June 29, 2022

**Re: Façade Renovation
7100 Menaul Blvd. NE
Traffic Circulation Layout
Architect's Stamp 03-28-22 (H19-D092)**

Based upon the information provided in your submittal received 06-29-22, the above referenced plan cannot be approved for Building Permit until the following comments are addressed:

**SITE PLAN**  
1" = 10'-0"

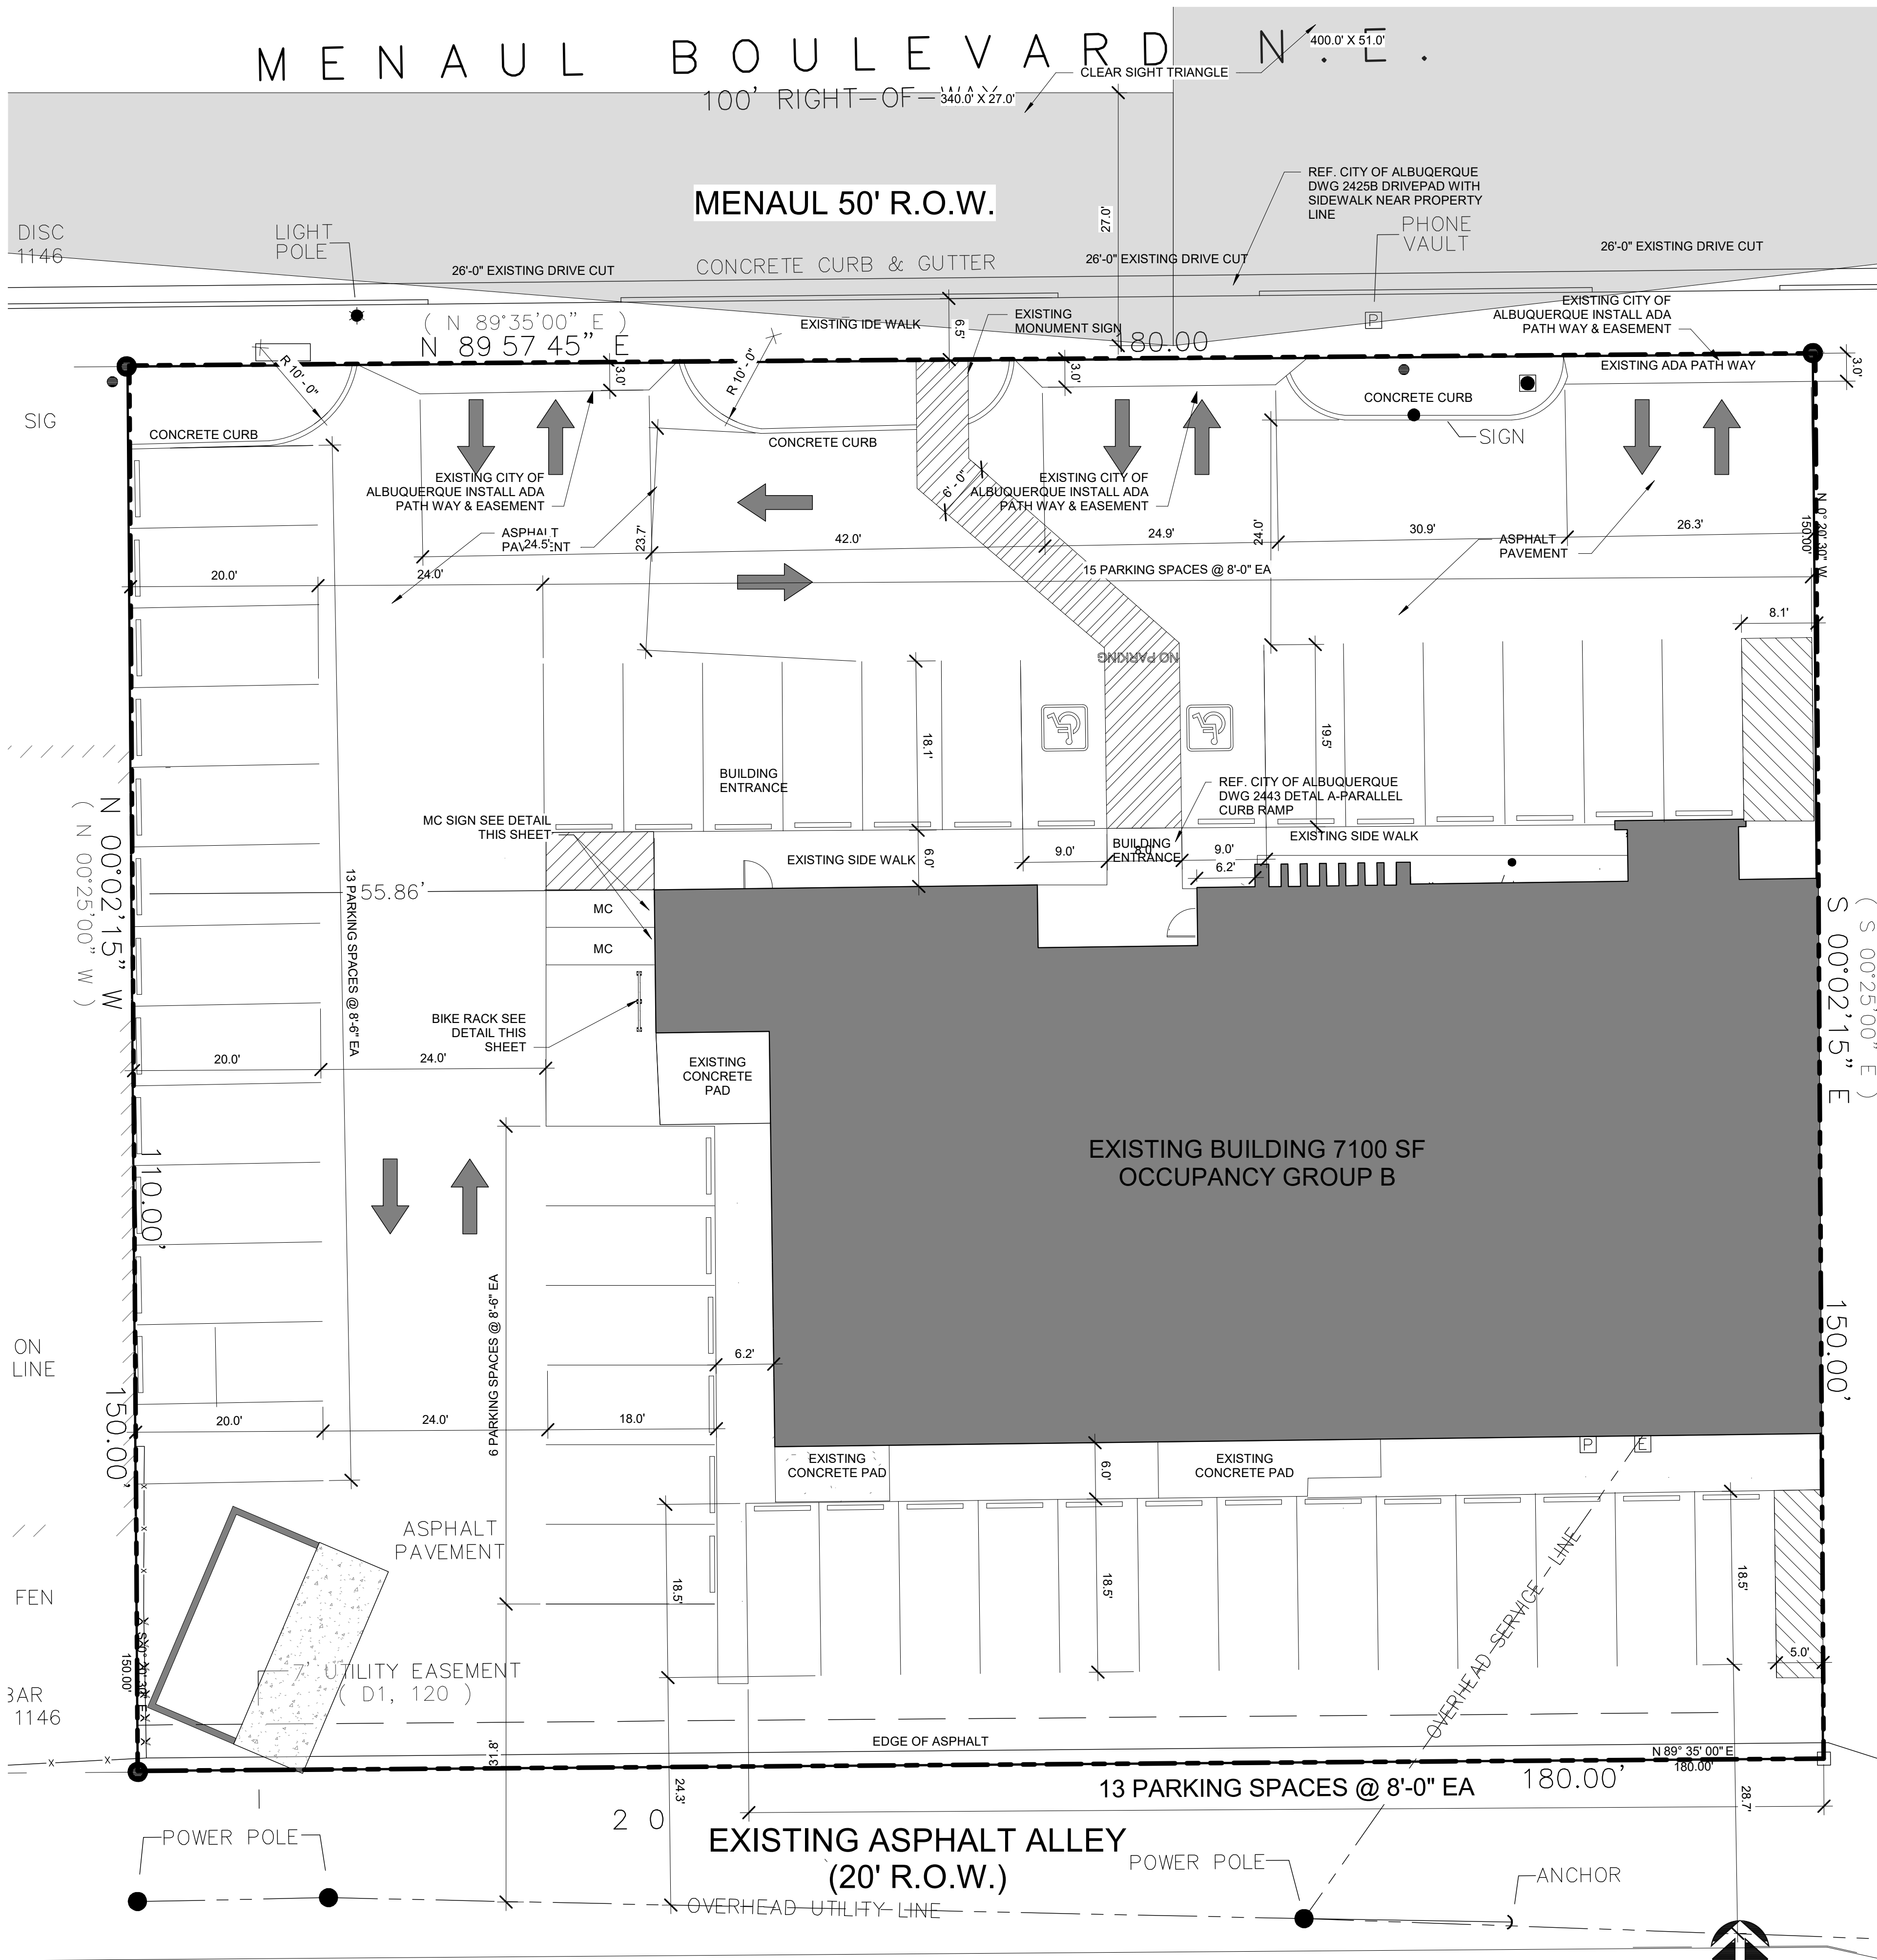
8. Refuse vehicle maneuvering shall be contained on-site. The refuse vehicle shall not back into the public right of way. **This includes alley way; provide a copy of refuse approval which was not included in resubmittal package.**

1 PARKING BUMPER DETAIL

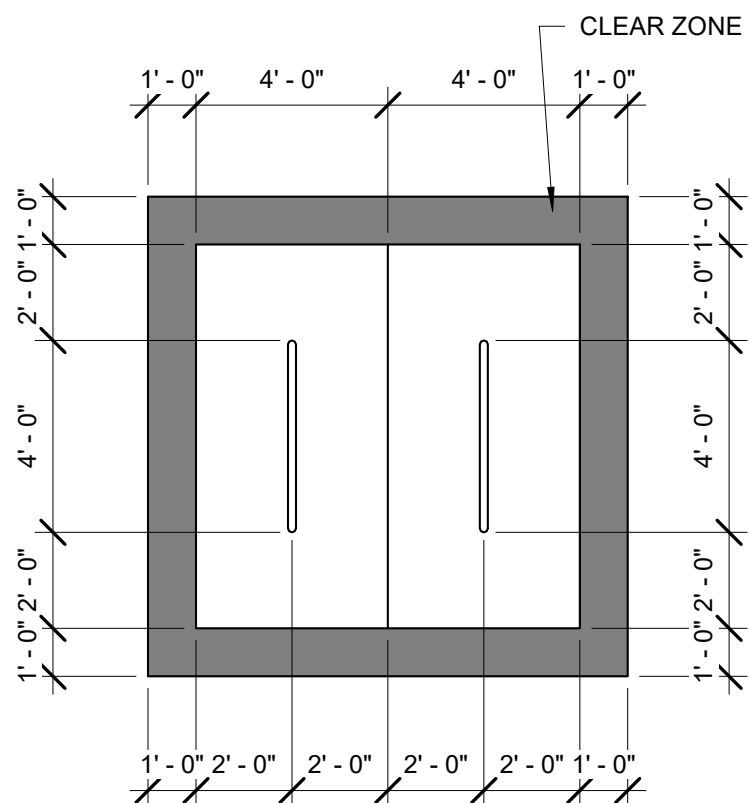
4. Parking areas shall have barriers to prevent vehicles from extending over 6ft ADA pathway to entrance. Please provide parking bumpers and provide detail.

SITE PLAN

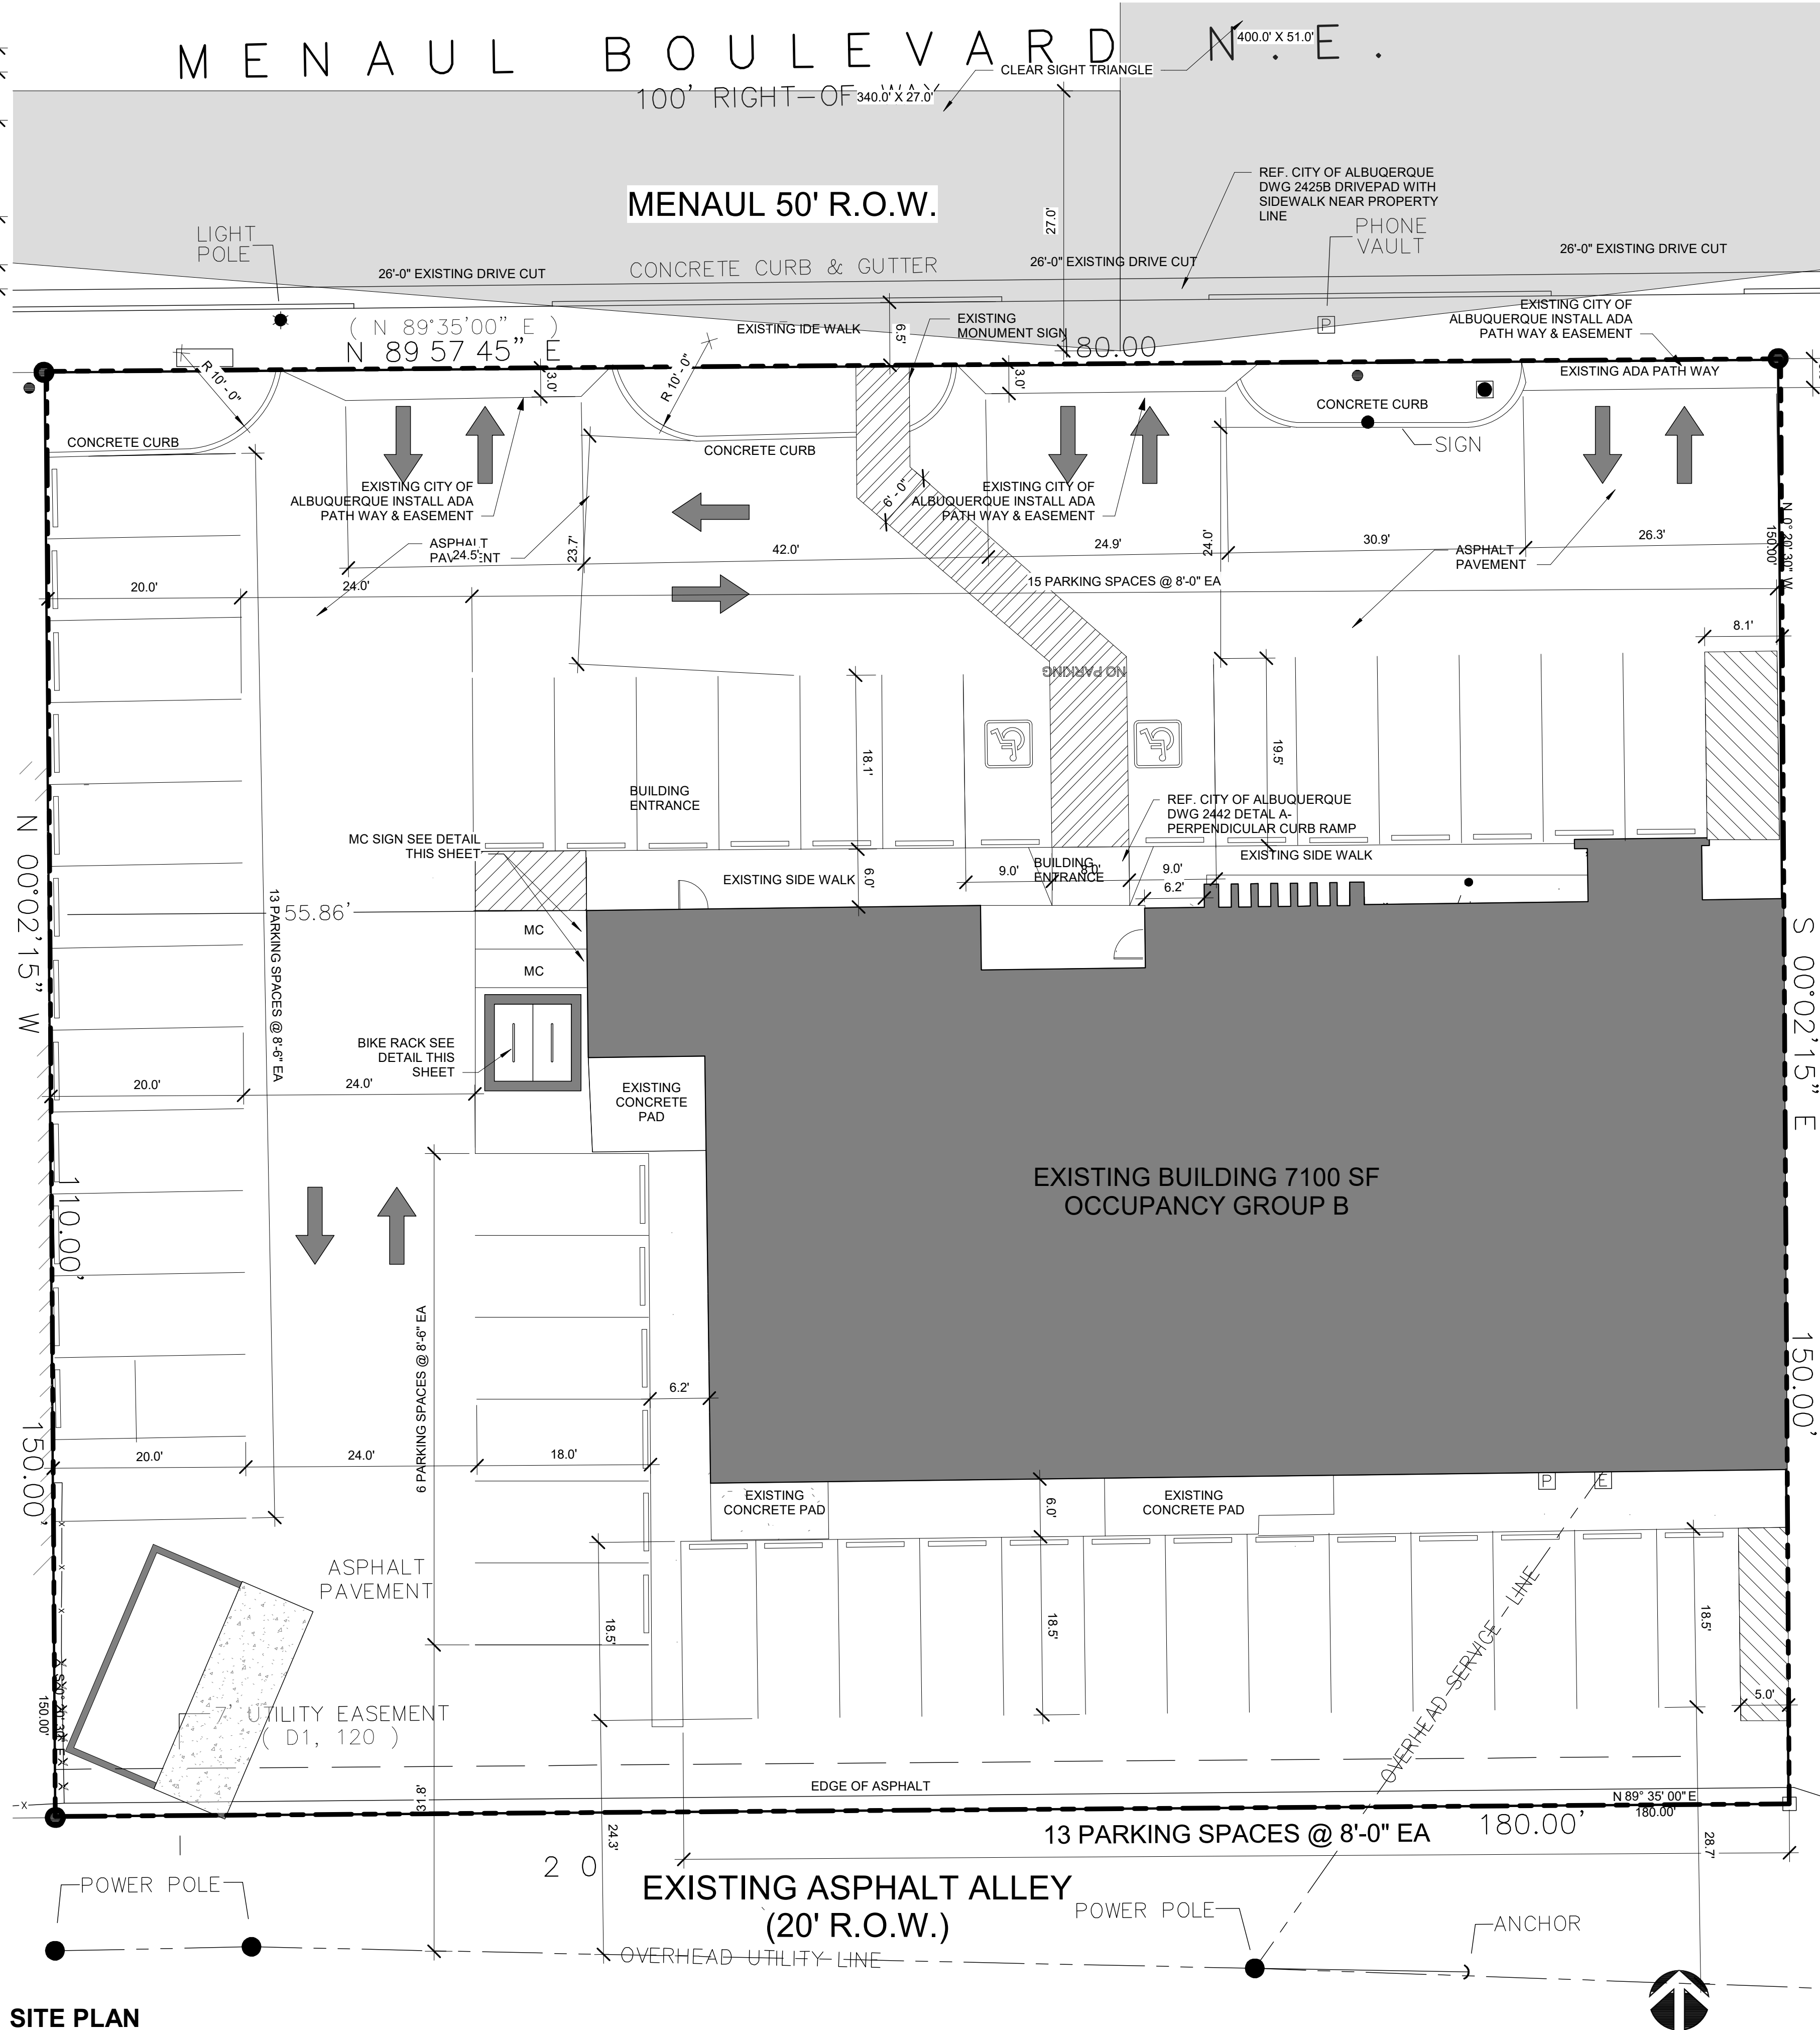
1. Motorcycle parking space: The signage is not shown on plans even though the detail is provided and detail will need to be provided for MC text.
2. Where is proposed 5 ft. keyway is required for dead-end parking aisles (Not shown/labeled on plans.

3. Show all building entrance and door ways on the site plan. Doorway versus the proposed ADA parking stall ramp. This might be an issue if a doorway is in front of the ramp. Please address.

5. Per DPM, a 6 ft. wide ADA accessible pedestrian pathway is required from the ADA parking stall access aisles to the building entrances. Please clearly show this pathway and provide details. This is not shown and might be impacted by overhang of vehicles.

6. The proposed 6ft wide ADA pedestrian pathway from public sidewalk appears to need a ramp prior to drive aisle. Please provide ramp and details.
7. What do you mean by RDGE OF ASPHALT?

9. The provided a sight line exhibit doesn't have dimensions. Please provide.
10. Add the following note to the plan: "Landscaping and signage will not interfere with clear sight requirements. Therefore, signs, walls, trees, and shrubbery between 3 and 8 feet tall (as measured from the gutter pan) will not be acceptable in the clear sight triangle.

11. Shared Site access: driveways that straddle property lines, or are entirely on one property but are to be used by another property, shall have an access easement. Please include a copy of your shared access agreement with the adjacent property owner.
